2. Bring the irrigation along eagle ranch Road up to city spec - 3 bubblers per tree. All trees along Eagle Ranch Road need to have irrigation installed. Drip irrigation is not allowed within the Right of Way area per the IDO:

3. Trim trees along Eagle Ranch Road per IDO specifications. Some of the trees are overhanging into the road which is not acceptable and it is the owner's responsibility to maintain these so they are not a hazard. Below are the relevant IDO codes for your reference:

# LANDSCAPE PLANTING PLAN

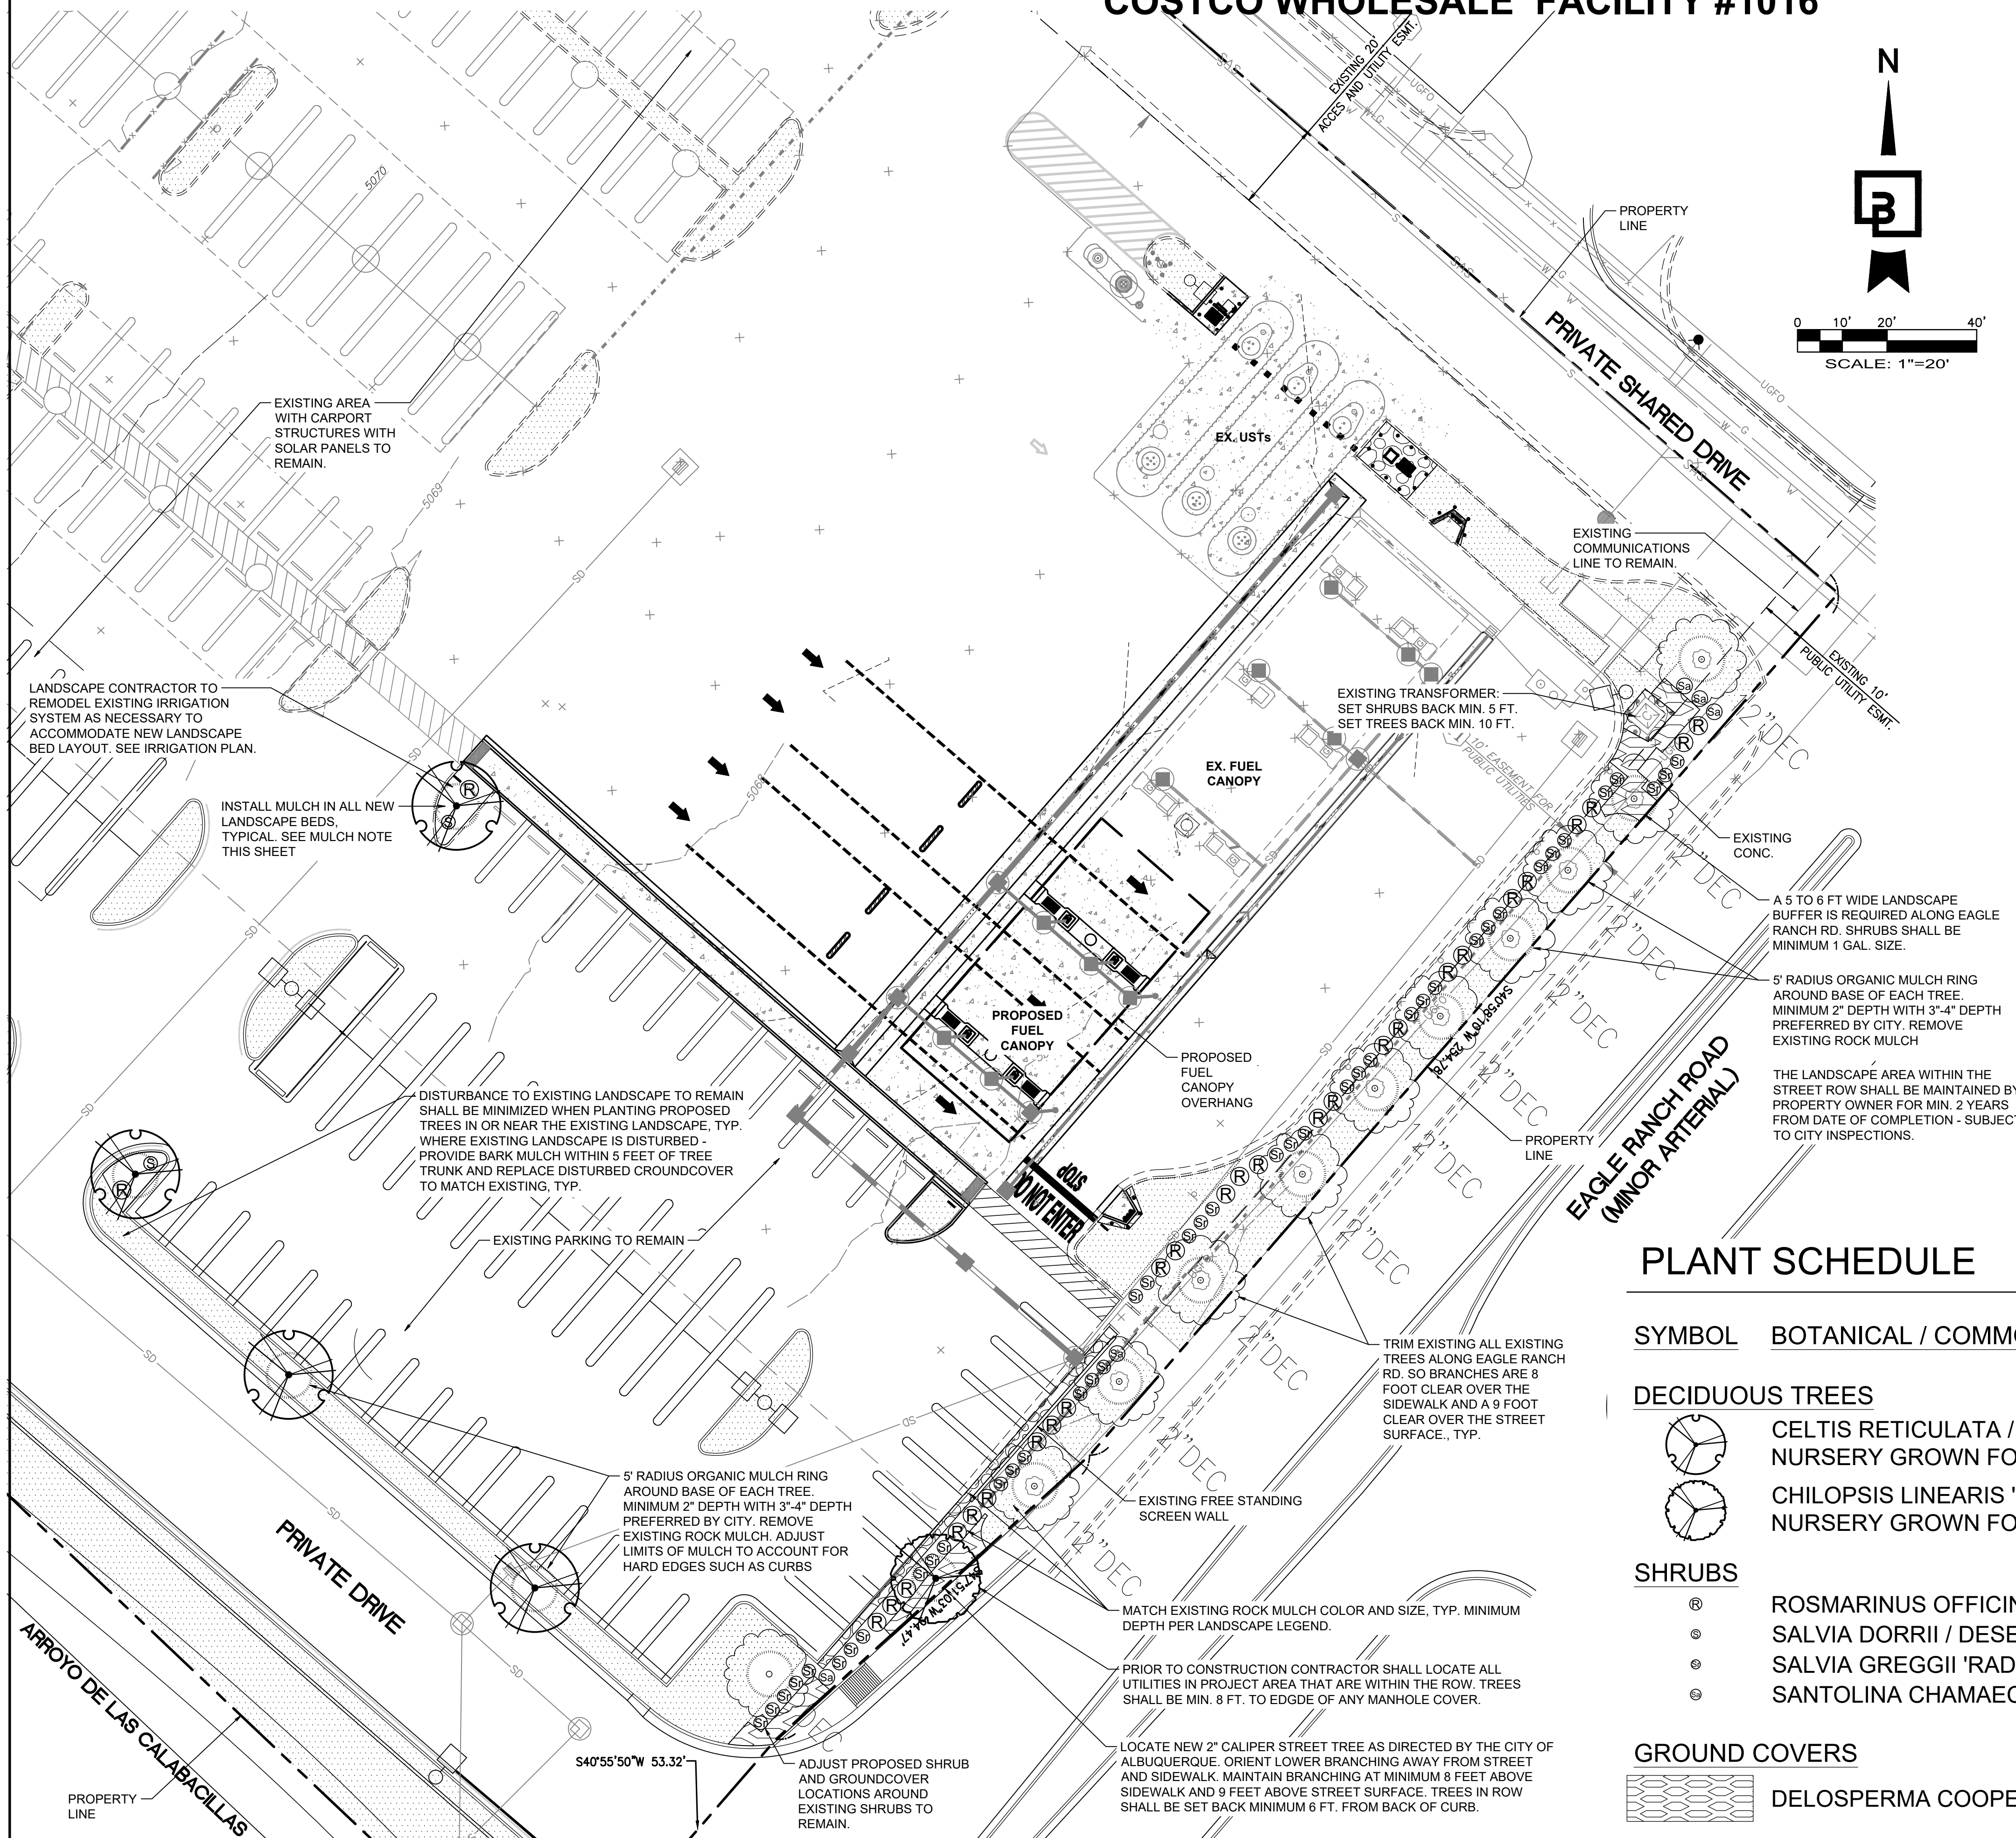
- 5-6(C)(9)(a) All planting of vegetated material or installation of any landscaping, buffering, or screening material in the public right-ofway shall require the prior approval of the City. The property owner shall be responsible for the maintenance, repairs, or liability for all the landscaping placed in or over the public right-ofway.

- 5-6(C)(9)(b) Any trees that overhang a public sidewalk or Major Public Open Space shall be trimmed to maintain an 8-foot clearance over the sidewalk. Any trees that overhang a public street shall be trimmed to maintain a 9-foot clearance over the street surface.

# LANDSCAPE IRRIGATION PLAN

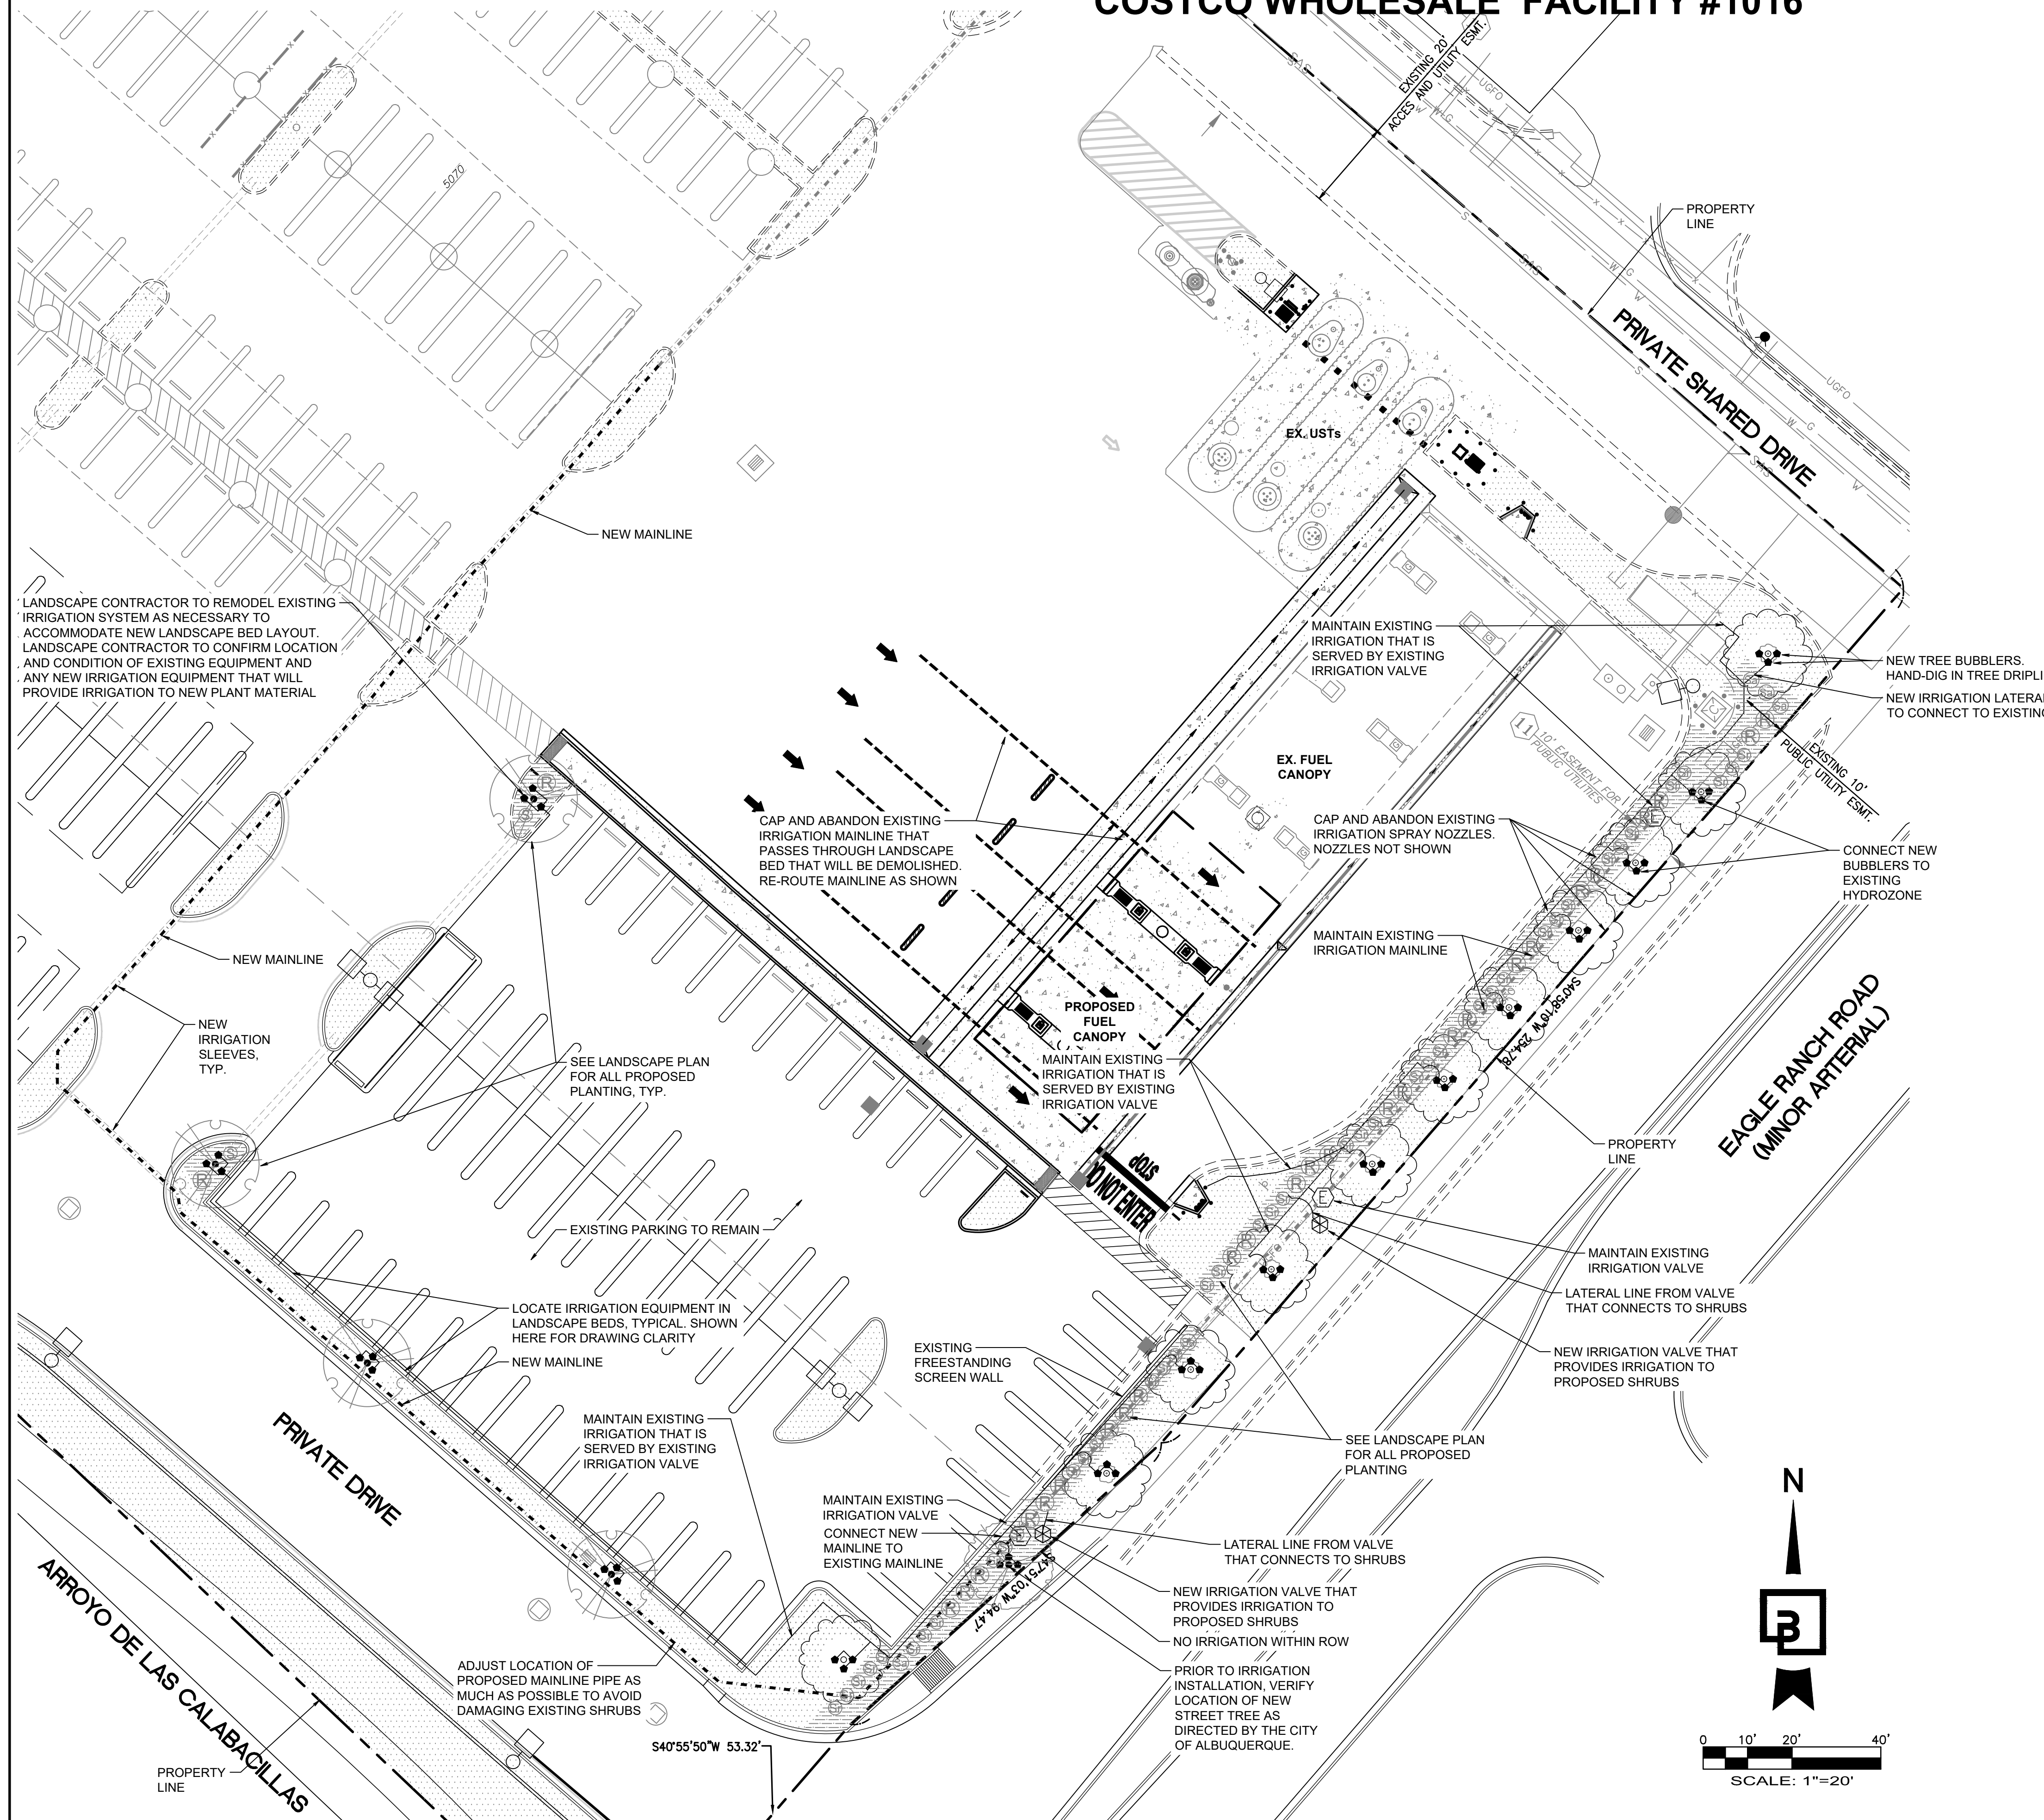
- 5-6(C)(9)(c) Where landscaping is installed in the public right-of-way, the applicant shall install an adequate irrigation system that meets the minimum technical requirements In Article 6-6 of ROA 1994 (Trees, Vegetation and Landscaping) and the DPM, with a separate meter for the landscape area in the public right-of-way, or a separate valve(s) at the property line allowing isolation of the irrigation to the landscape within the public right-of-way. Drip irrigation systems and artificial turf shall not be allowed within the public right-of-way.
